**From:** Craig Dalton <Craig.Dalton@hnehealth.nsw.gov.au>  
**Sent:** Monday, 29 May 2017 11:14 AM  
**To:** Steve O'Donoghue  
**Cc:** Peter Falkiner  
**Subject:** FW: Narrabri Gas Project (SSD 6456)

Please find below the Health response to SSD 6456, Narrabri Gas Project.

I refer to the Environmental Impact Statement for the proposed development of a gas production field by Santos NSW (Eastern) Pty Ltd at Leewood, 20km southwest of Narrabri, New South Wales (NSW). The proposed development seeks to develop and operate a gas field requiring the installation of 850 wells, gas and water gathering systems and supporting infrastructure in the Pilliga area.

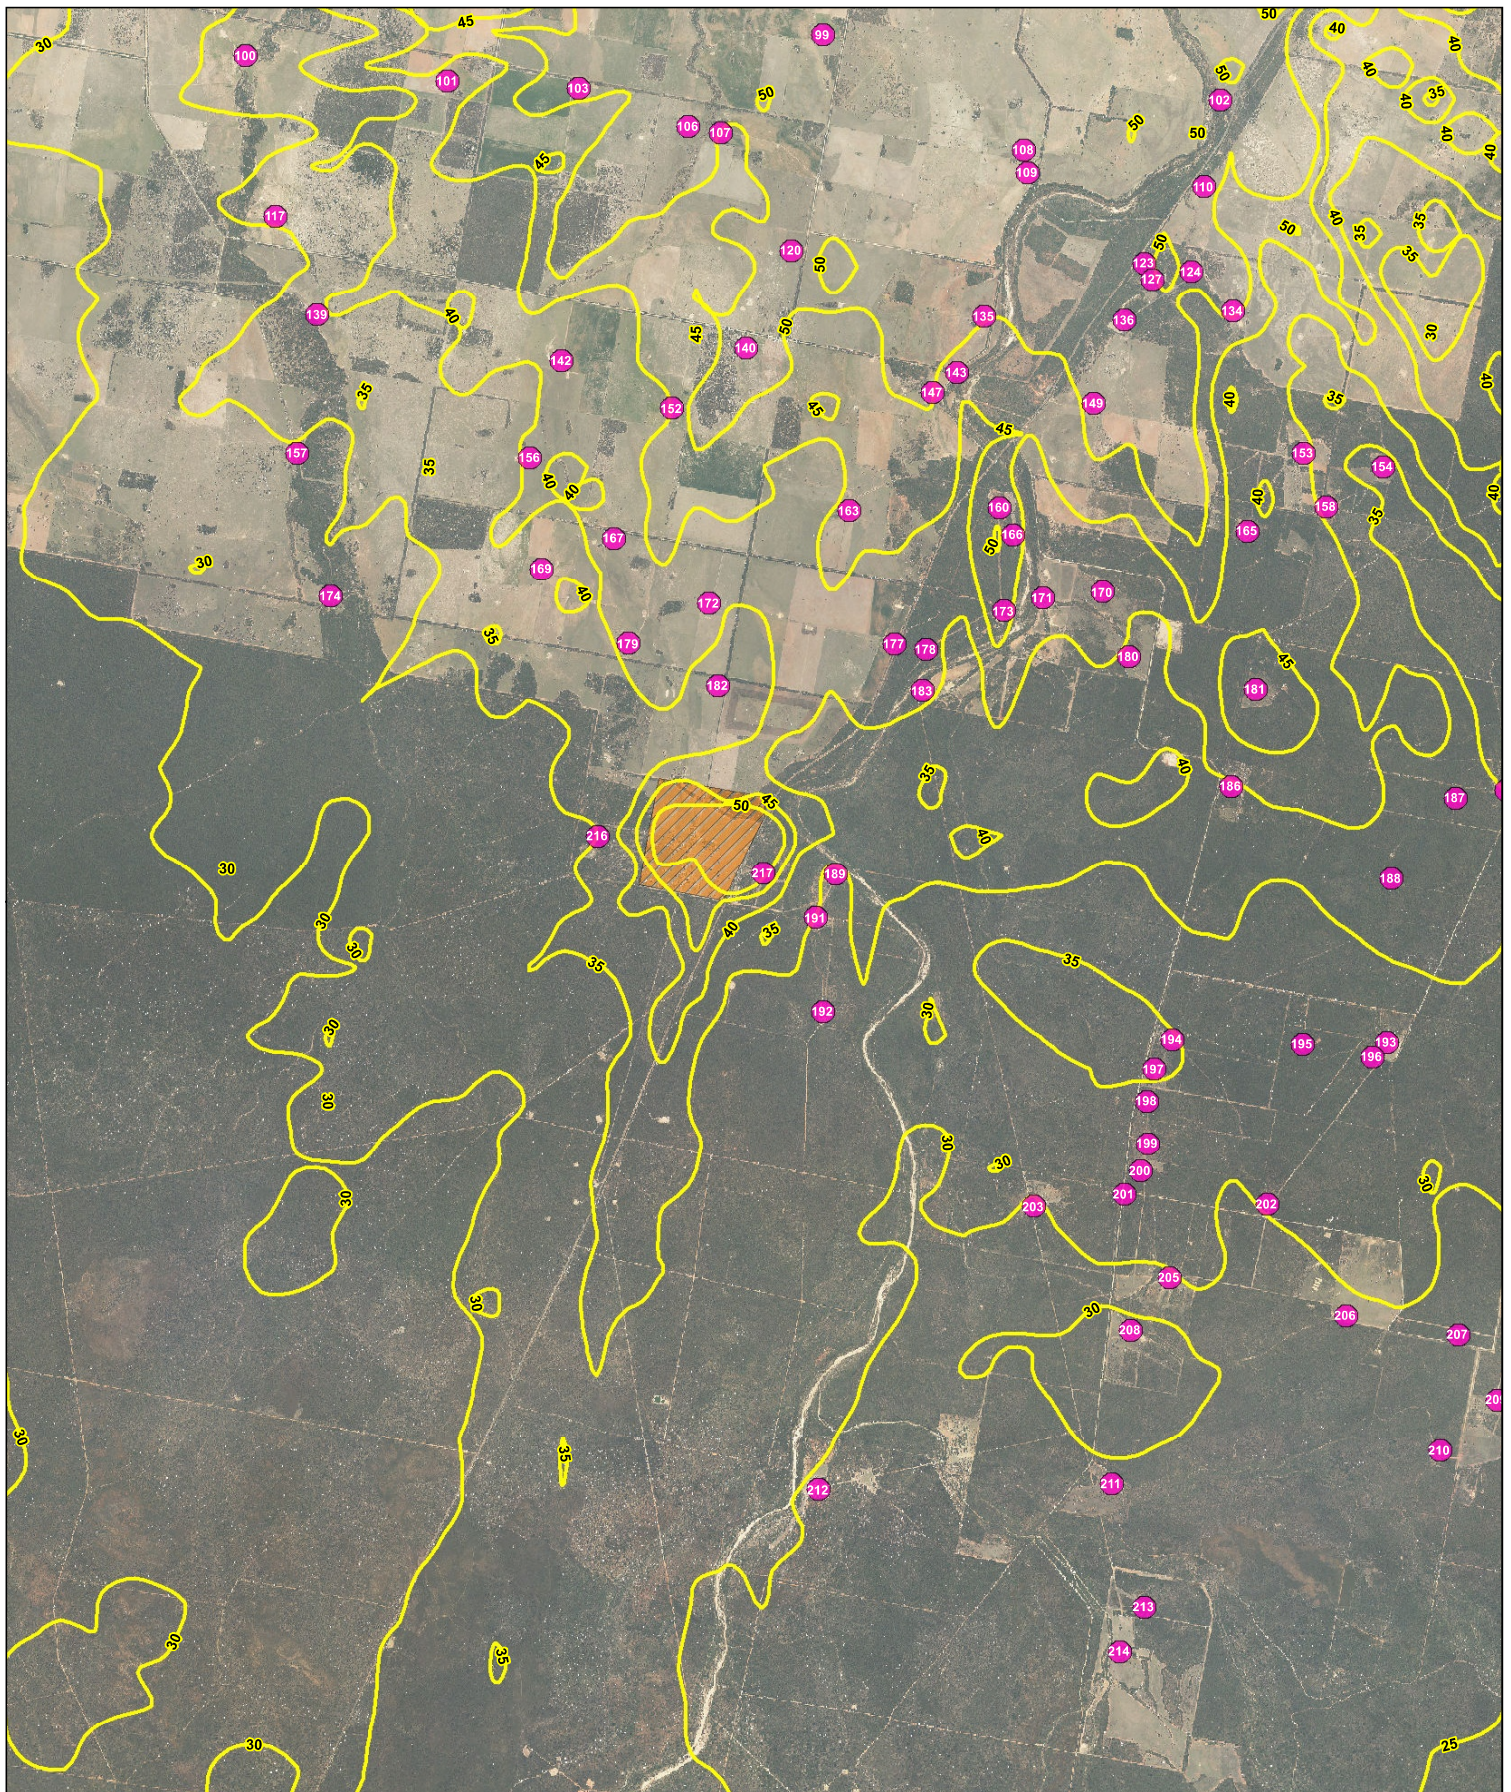
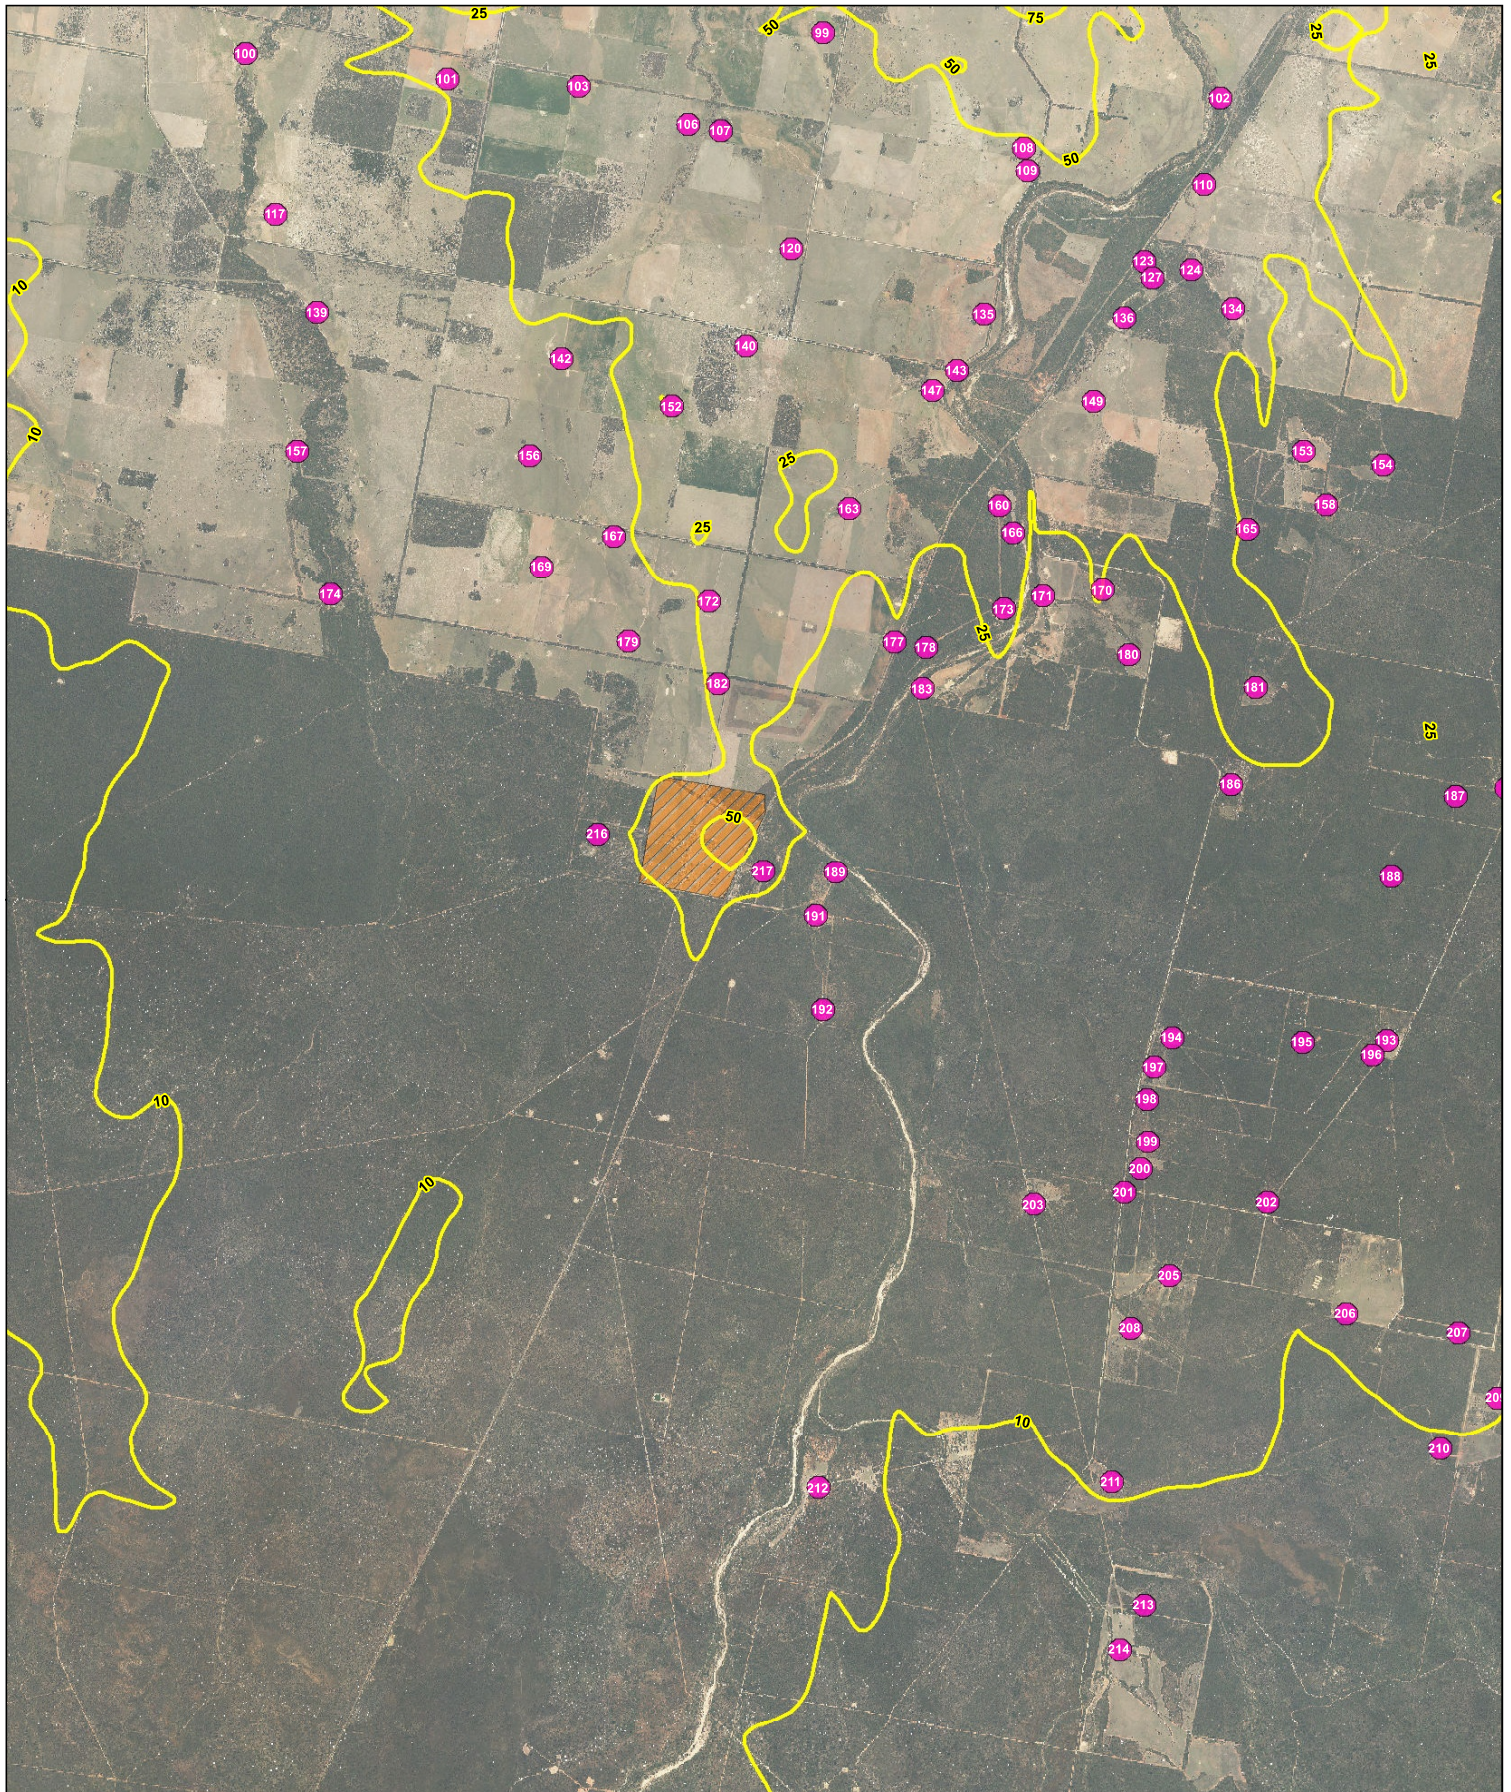
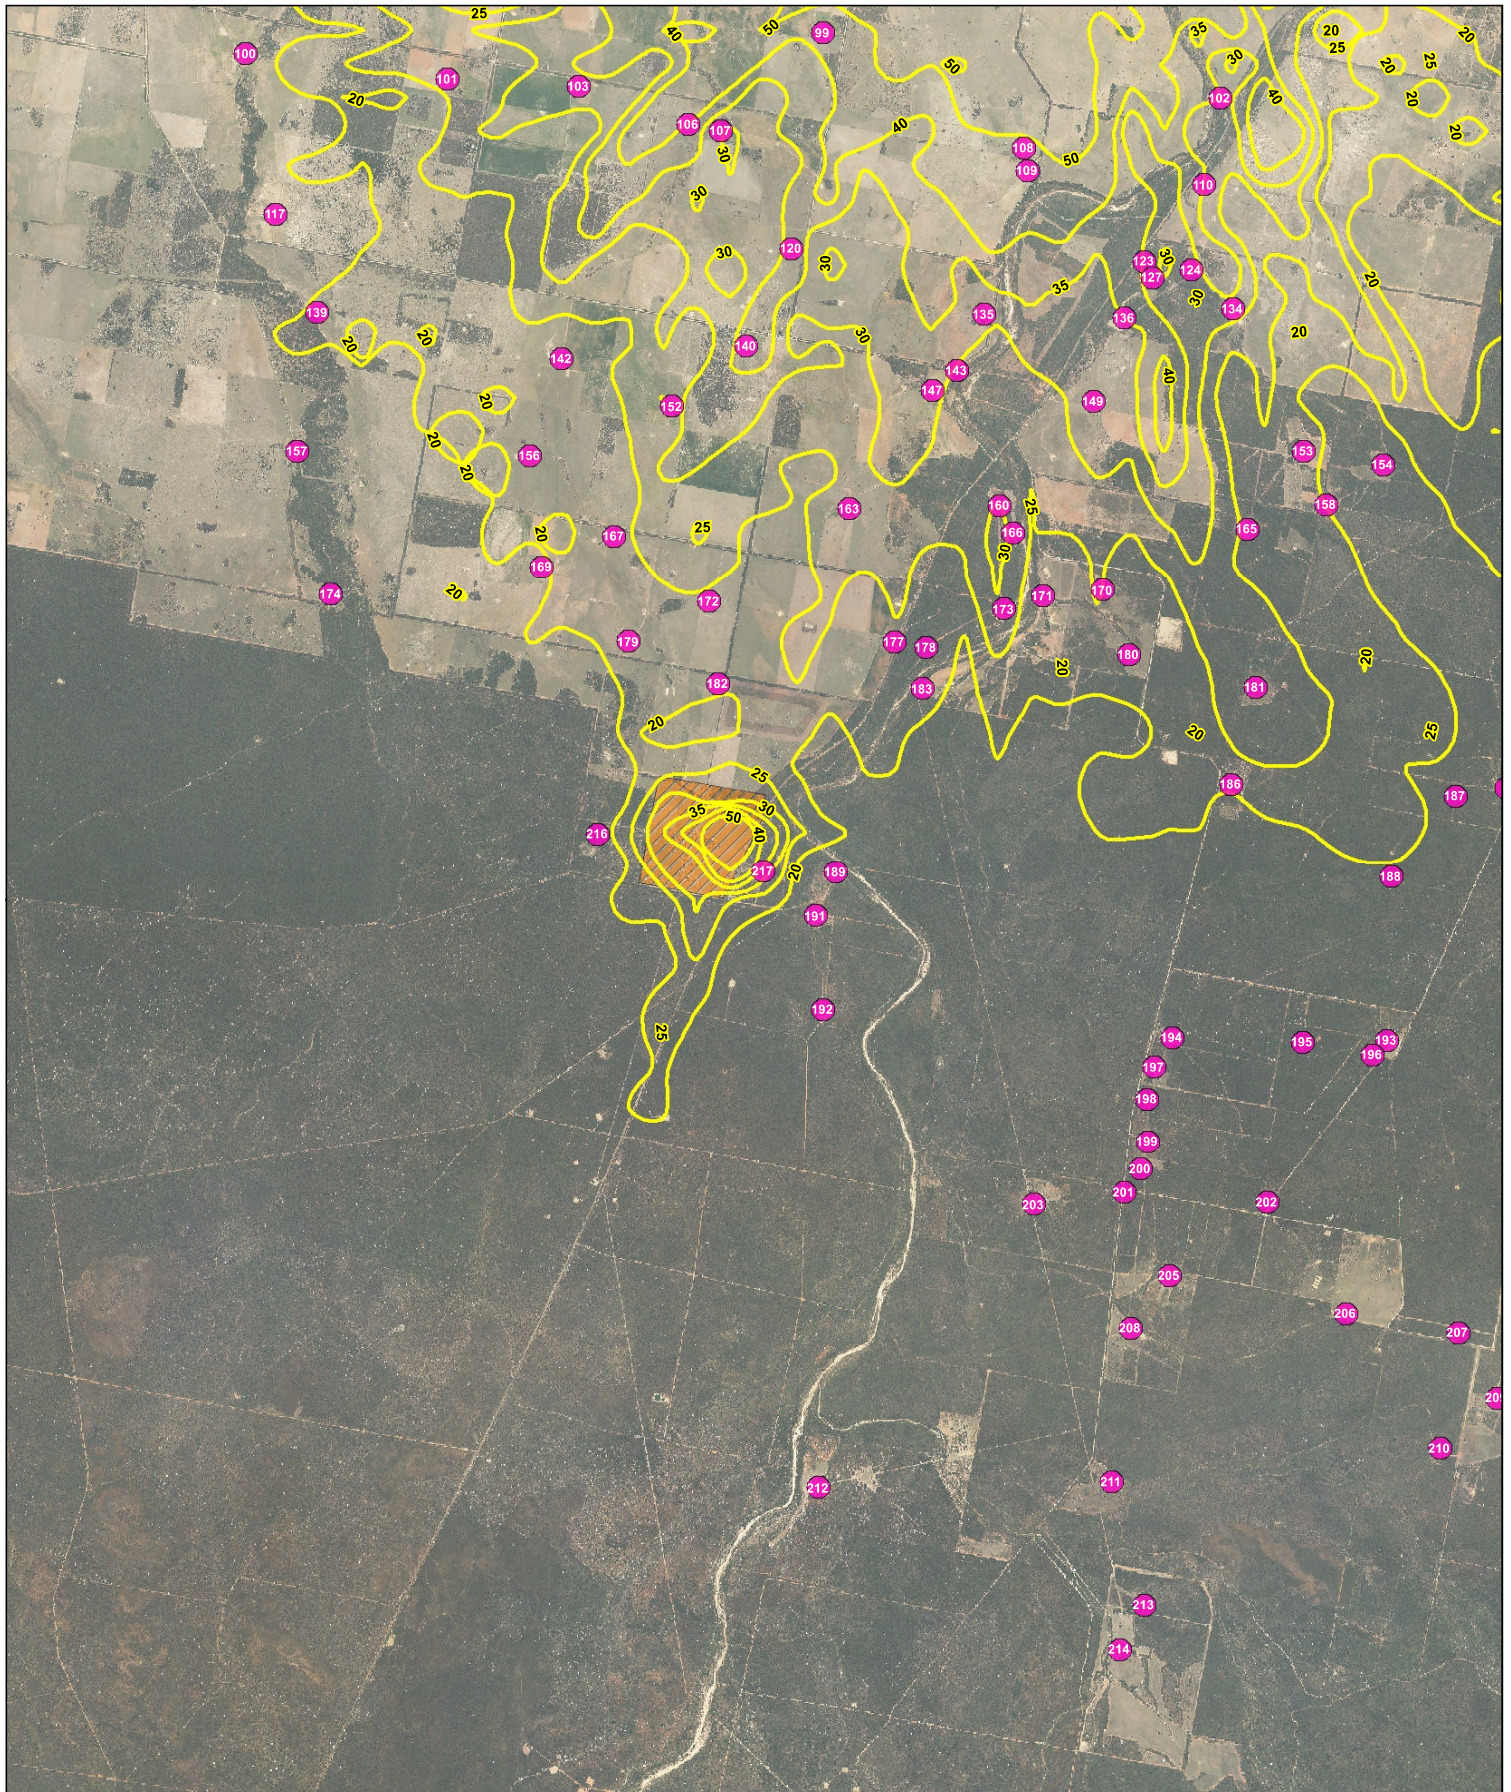
The EIS states that assessment criteria for all key pollutants will be met outside the boundary but the assessments are not shown. Air concentration contours are shown only for short term NO<sub>2</sub> and a graph displays concentration/distance for short term PM<sub>10</sub>. It will be important to show modelled contours of the air pollutants in relation to receptors (as is usually done for mine sites). Air concentration contours for annual PM<sub>2.5</sub> will be of particular interest to those concerned about health. Predicted concentrations of air toxics at receptors will also be of interest.
